Phone: 0300 123 6780
Email: Kathryn.Walsh@lancashire.gov.uk
Your ref: 3/2024/0213
Our ref: 3/2024/0213/HDC/KW
Date: 12 March 2026

Location: Eight at Gazegill Gazegill Organics Dancer Lane Rimington BB7 4EE
Proposal: Retrospective planning application to continue use of single storey restaurant building, outdoor seating area, play area and vehicle parking area.
Grid Ref: 382097 446306

Lancashire County Council acting as the Local Highway Authority (LHA) does not consider that the application as submitted fully assesses the highway impact of the proposed development and further information is required as set out in this response.

Drawing; Dancer Lane Key

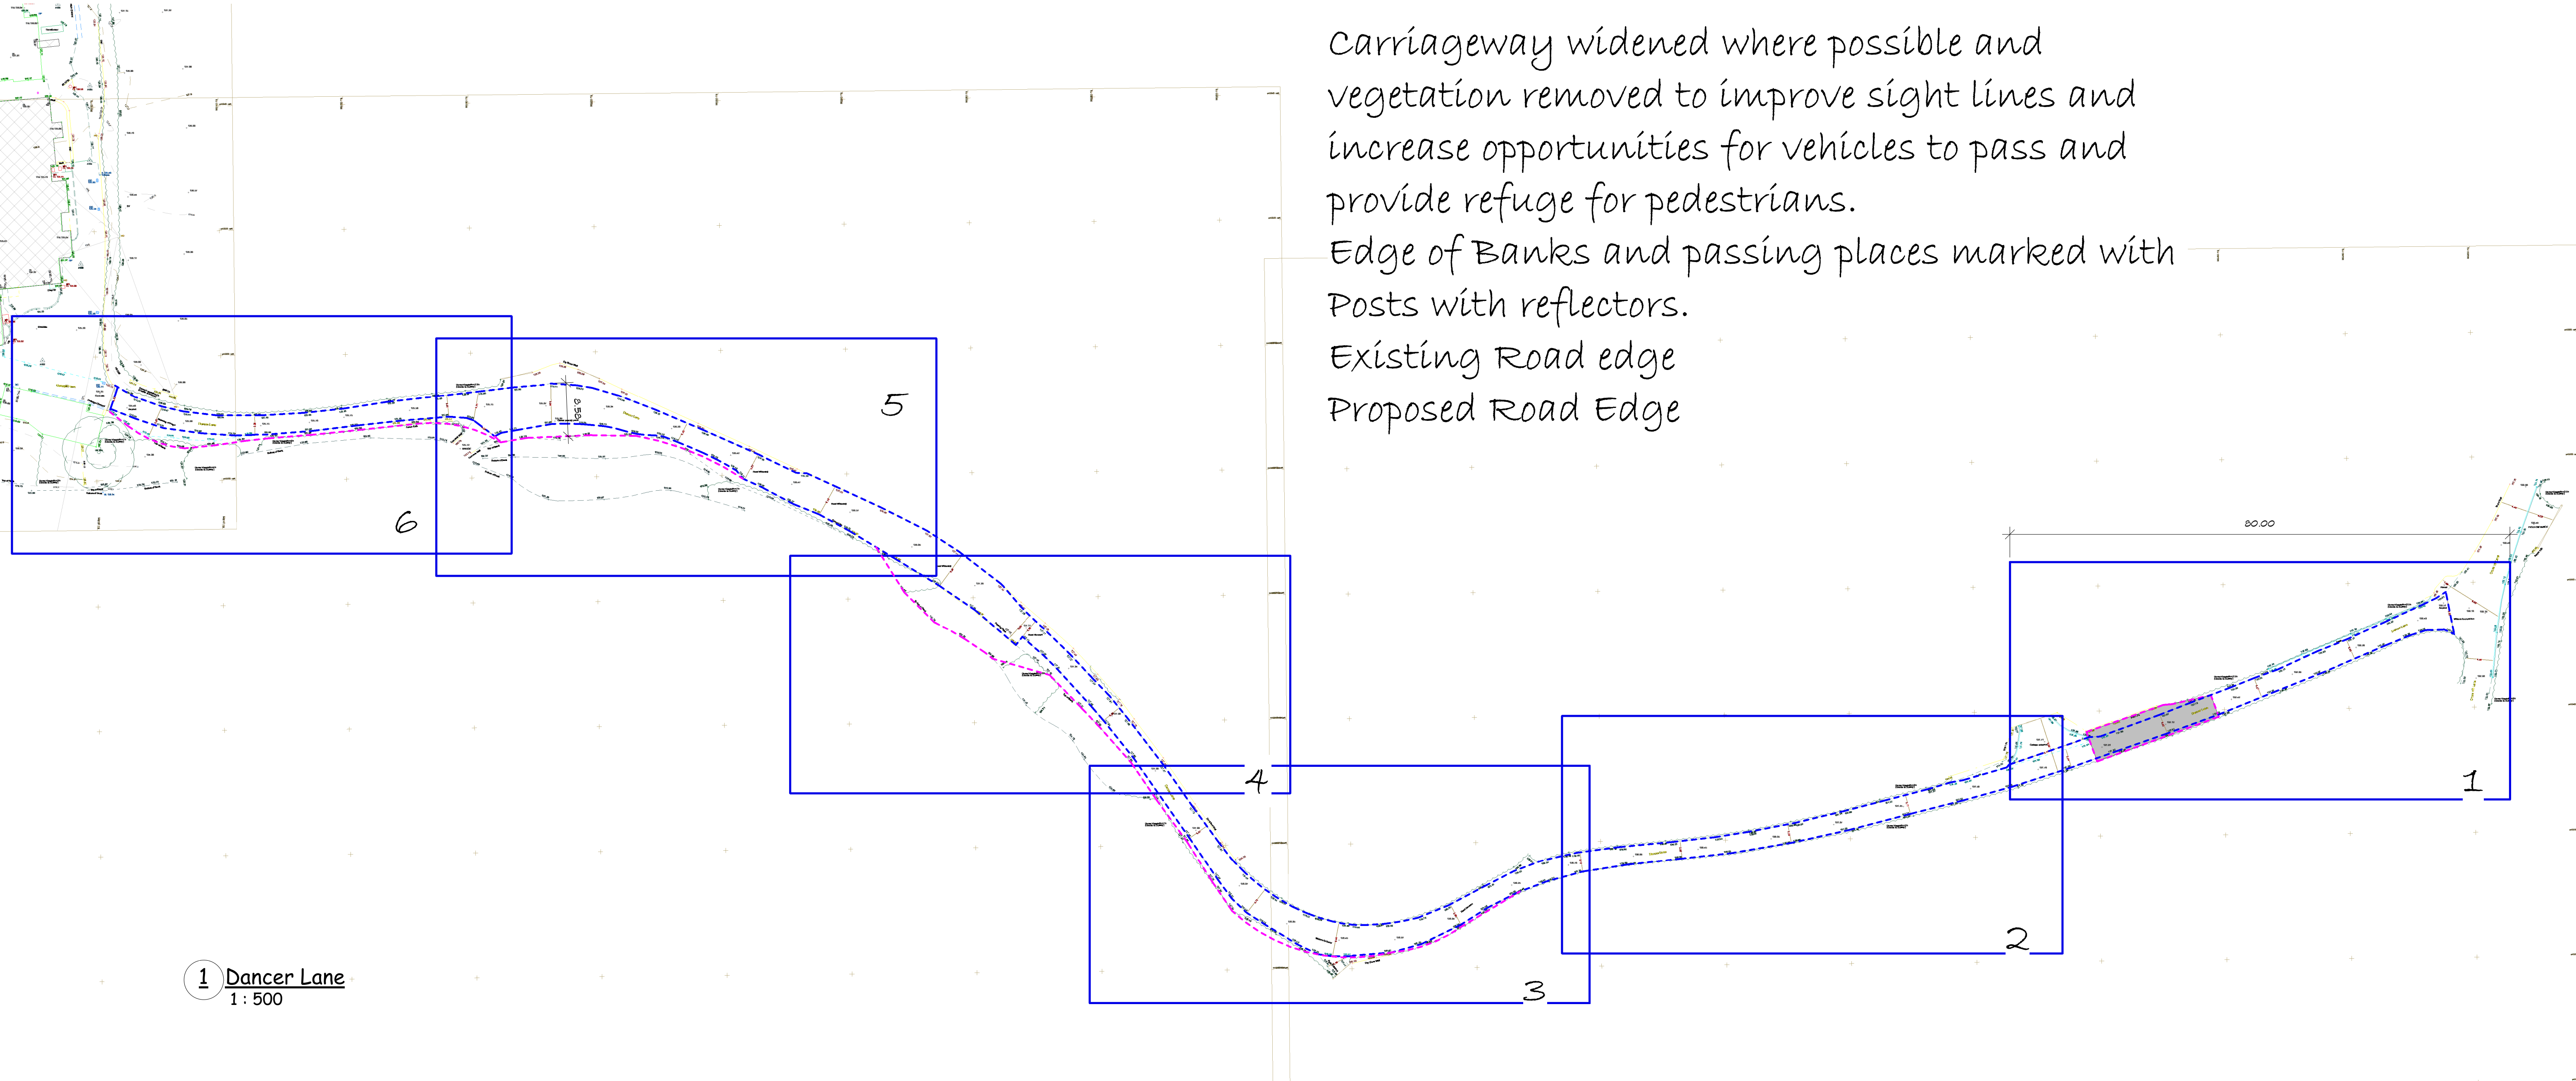
In aim to address the LHAs previously raised concerns the applicant identifies five informal passing locations three of which have been recently implemented. These vary greatly in usability; some are simply widened verges or gateway entrances as such the LHA will comment on each location below.

Whilst the LHA note that two-way vehicle movement could take place in the informal passing place locations one, two and four, this does not omit concerns that conflict is likely in these locations, these access points do not appear to fall within the applicants control and as such third parties access could be detrimentally affected. It is also possible that third parties do not support this use and as they have control over their own access points, they could stop use in this way by physical means at any point in time. As such future proofing these suggested passing place is questionable.

The LHA would also raised concerns over the future proofing of the other passing places as none are suggested to be formalised, formally surfaced, or protected, which means performance in wet weather, darkness, or during verge saturation is questionable. Two are located on bends and could be constrained by limited visibility, it is noted that no forward visibility drawings have been provided. The LHA did raise concerns over forward visibility along the road previously.

The first 200m from Cross Hill Lane still has no viable passing opportunity, given that they can only be provided by utilising existing access points meaning two vehicles meeting head-on may still need to reverse a considerable distance or even out of the junction which is not supported. Therefore, despite the improvements, the route still fails to meet minimum standards for safe two-way movement for an intensified commercial use.

The continued maintenance of these passing places is also questionable due to the ownership or control not being clearly identified. Due to this the applicant cannot include these passing places within their red edge and as such the LHA cannot impose necessary conditions which future proof their existence.

- A detailed, scaled site access plan, including dimensions and any proposed widening.
- Clear identification of passing places within the applicant's control with evidence that these can be secured, maintained, and conditioned long-term. To confirm which areas of Dancer Lane and proposed passing places fall within the applicant's ownership or influence.
- Drawings demonstrating available visibility along Dancer Lane, at each passing point.
